Approval of details reserved by condition imposed under ref APP/C3810/W/18/3197149 (LU/162/17/PL relating to Condition Nos 8 - materials & finishes, 9 - landscaping scheme, 10 - Construction Management Plan, 13 - visibility splays, 14 - pedestrian visibility plays, 16 - cycle parking and 18 - street lighting.

Land At Toddington Farm North And West Of 1 To 3 Toddington Toddington Lane Littlehampton BN17 7PN

Arun District Council have decided to **REFUSE details reserved by condition for the following reasons:**
This condition cannot be discharged on the basis of the information submitted:

Proposed Site Plan - 1:200 @ A1

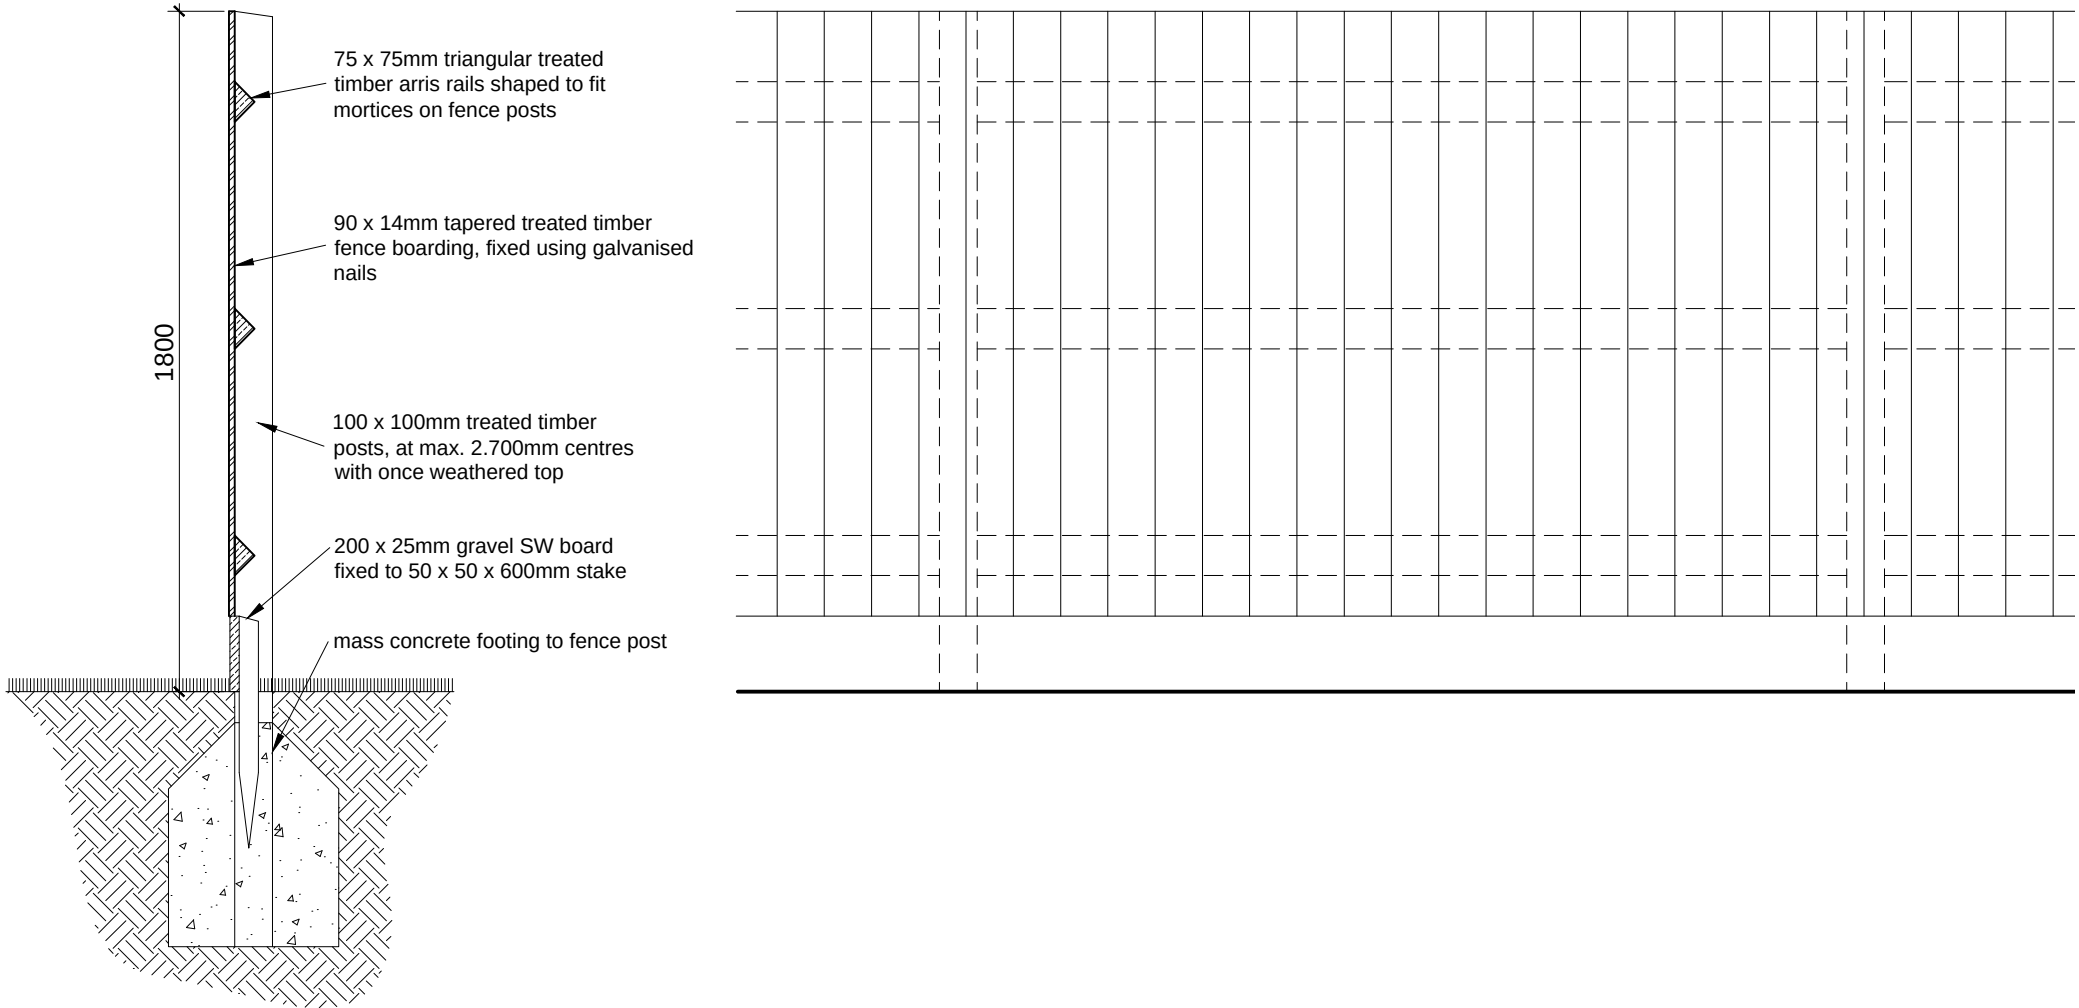
The site layout dwg submitted at approval dwg no (00) 002 rev G 20.01.17 contained a LAP within the

POS area the layout dwg above now appears to omit this from the detail. It should be included.

Drawing Title:
Detailed Planting Plan

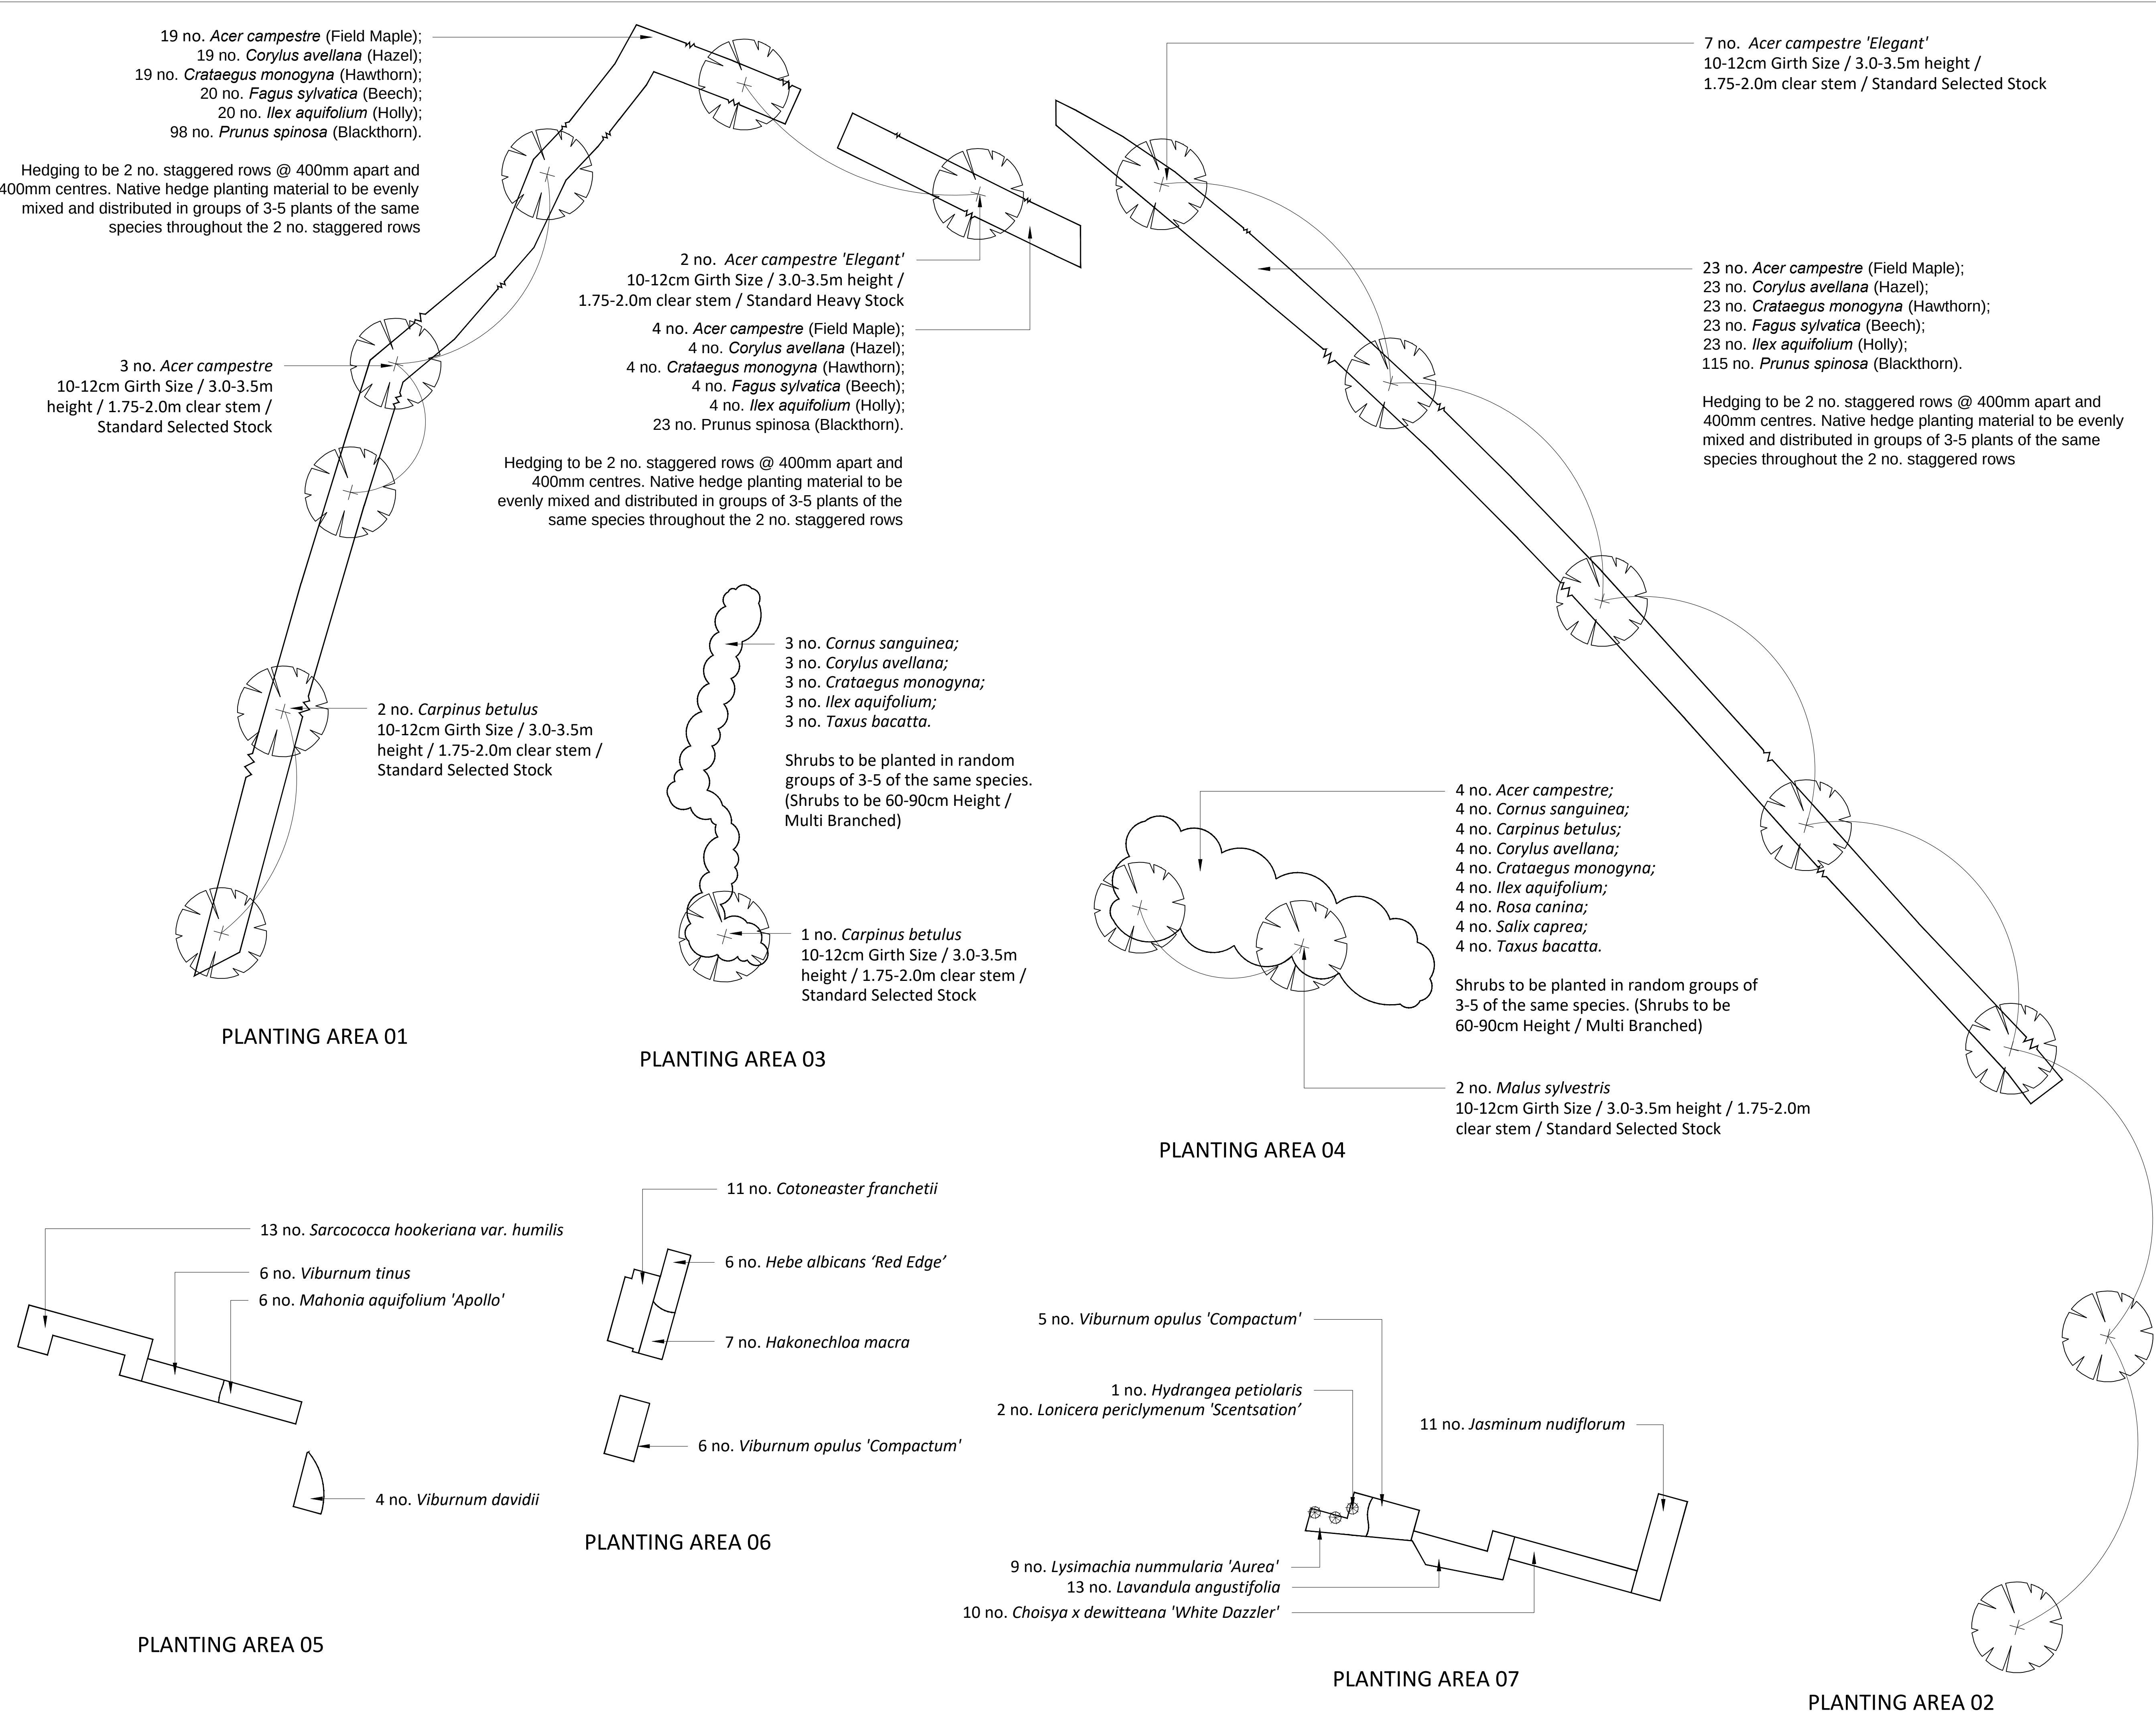
The proposed species for the hedgerow and trees adjacent to the footway are suitable and characteristic of a more rural location, despite the increasing housing development in the vicinity. The trees are a more compact form of field maple and a medium sized tree at maturity. However, it is preferable to adjust the species mix of the hedge, reducing the blackthorn component, increasing the hawthorn component and removing the beech so that the mixture is along these lines: 60% hawthorn; 4 x 10% minor species.

There is conflict between the lighting column plan and the planting plan. In places, columns are shown right next to trees so this needs adjustment. Similarly, all drainage and ducting for services MUST not conflict with the planting to avoid damage if repairs / replacement is needed in future.

A long term maintenance plan for the planting should form part of the detail.

Details of what edge restraints are proposed for the footway to be provided. Is a fence proposed behind the hedge or in front of it? Ideally not, but a temporary one may be necessary to protect the planting as it becomes established.

Finally, there does not appear to be any reference to protection for the hedging/shrubs. Are shrub shelters/stakes/other guards proposed? Tree/shrub shelters/protection is not mentioned but these may not be required unless there is an evident rabbit population in this area. Shelters have the potential over time to be a hazard, form litter as they degrade and come adrift and would require a maintenance obligation for their removal after a period of approx. 3-5 years if not to be detrimental to the establishing plants.

Planting to be adjusted in location where conflict with lighting columns occurs.
